[REDACTED]
Subject: Highways England response: Planning Consultation on WA/70/20/DOC, Land East of Tye Lane, Walberton

Planning Application No: WA/70/20/DOC

Site: Land East of Tye Lane, Walberton

Development: Approval of details reserved by condition imposed under ref WA/44/17/OUT relating to Condition No 6 - Construction Management Plan.

Scale AS SHOWN	Date MAY 2020	Designed by KI
Drawn by KI	Checked by DH	Approved by KM
Drawing Number 183244-001		Rev -

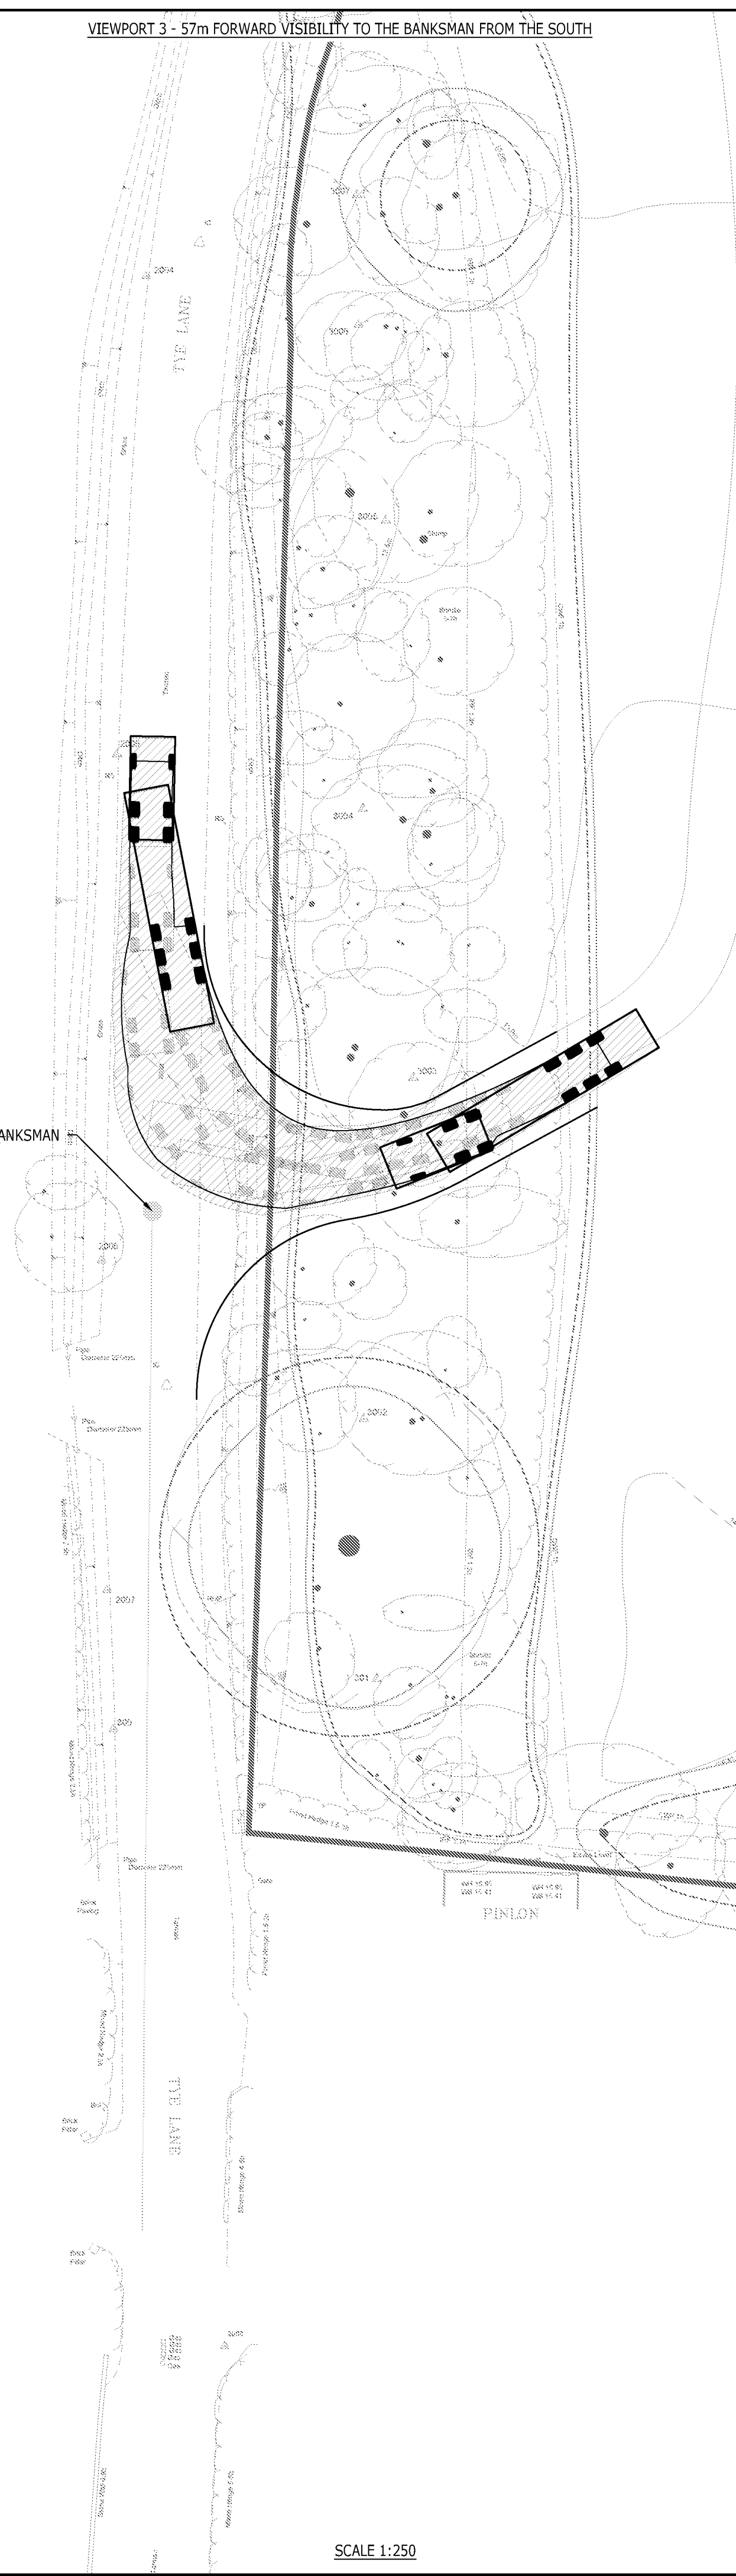
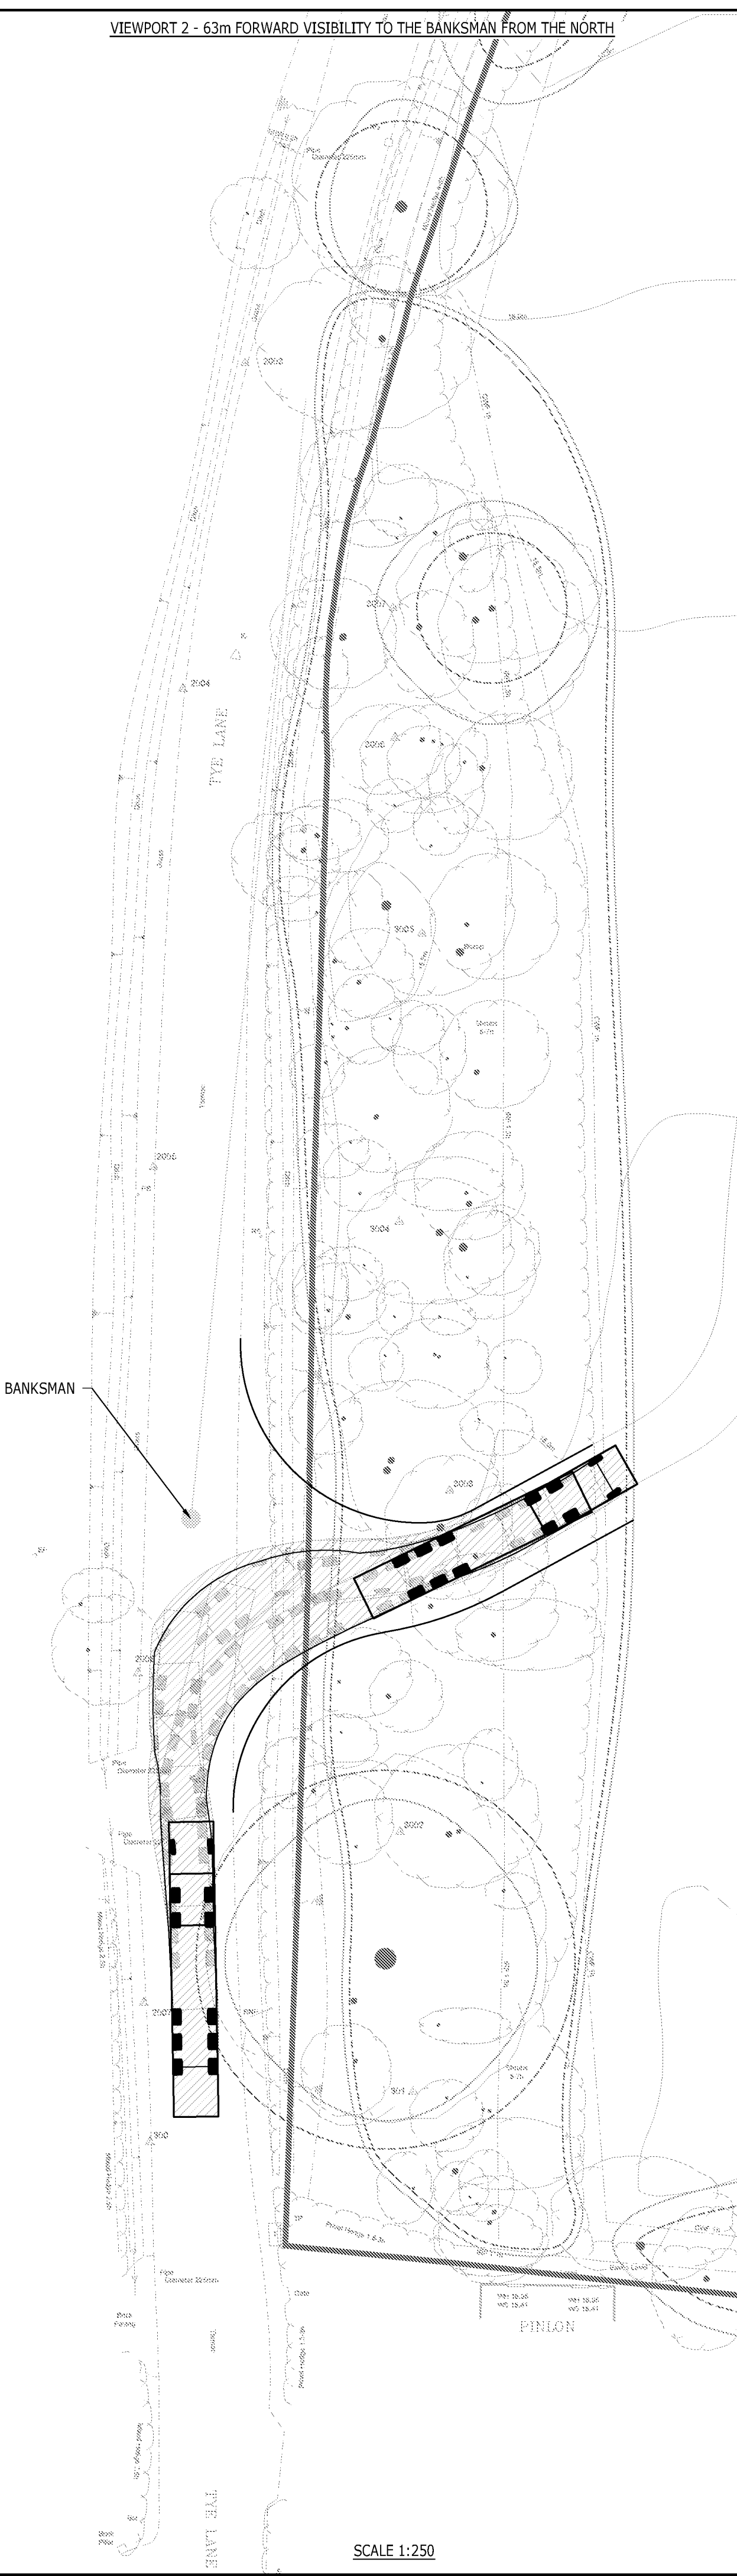
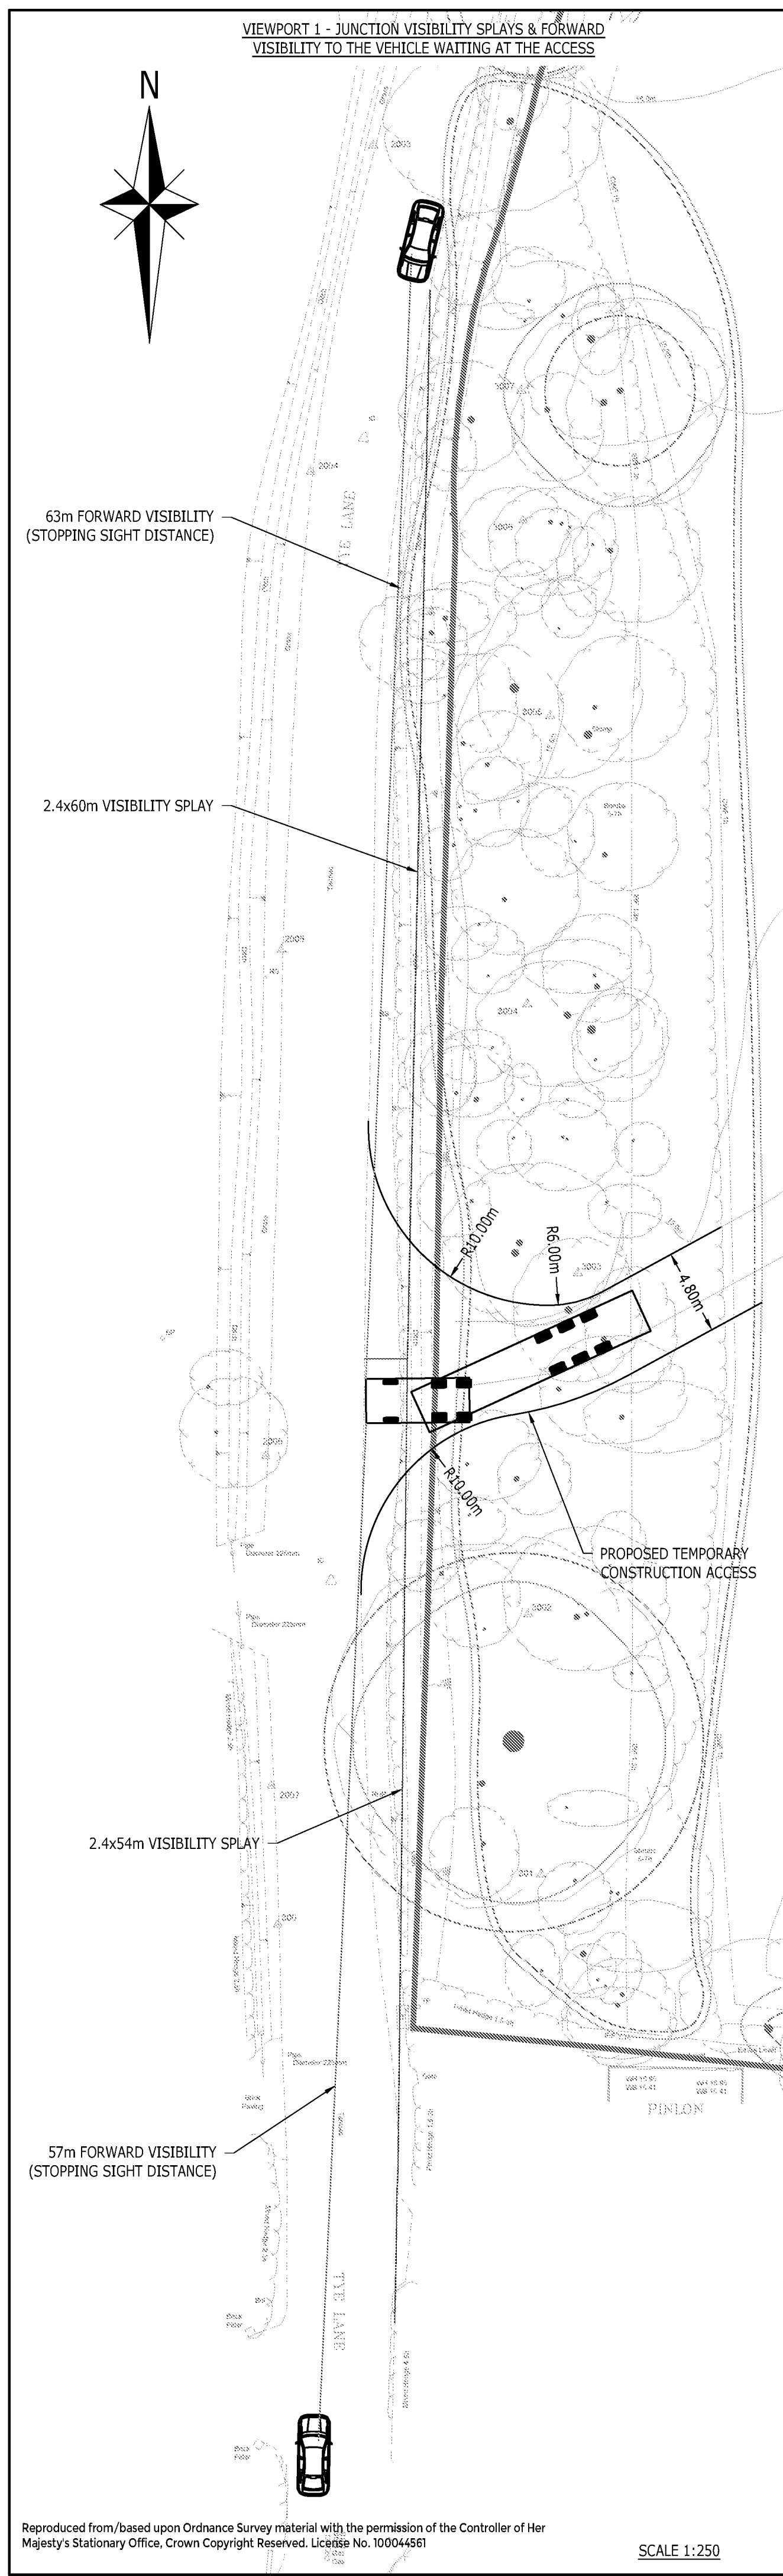
With the proposed change to construction traffic routeing, all construction traffic to and from the A27 would use the A27 / Tye Lane junction instead of the A27 / Yapton Lane junction. The Tye Lane access onto the A27 is not suitable for heavy construction vehicles: there is no acceleration lane or merge taper and so heavy, slow accelerating construction related vehicles would be pulling out into a high speed road from a standing start. This is not acceptable because of the inherent safety risk of heavy, slow moving traffic entering the A27 carriageway and conflicting with high speed traffic on the main line. Therefore all heavy construction traffic accessing the A27 should use the Yapton Lane junction where there is an appropriate acceleration merge taper.

We therefore require assurance within the Construction Management Plan that heavy, construction related traffic from the site will not turn into the A27 at Tye Lane because of the inherent safety risk. We also wish to see details of how the developer will manage, monitor and enforce a restriction preventing heavy construction vehicles using the A27 / Tye Lane junction to enter the A27.

In view of our safety concerns, Highways England currently objects to the proposed alteration to the approved Construction Management Plan required by Condition 6 which would allow construction traffic to use the site access onto Tye Lane. Accordingly we request that your Council does not approve this application unless and until the Construction Management Plan has been amended to address our concerns.
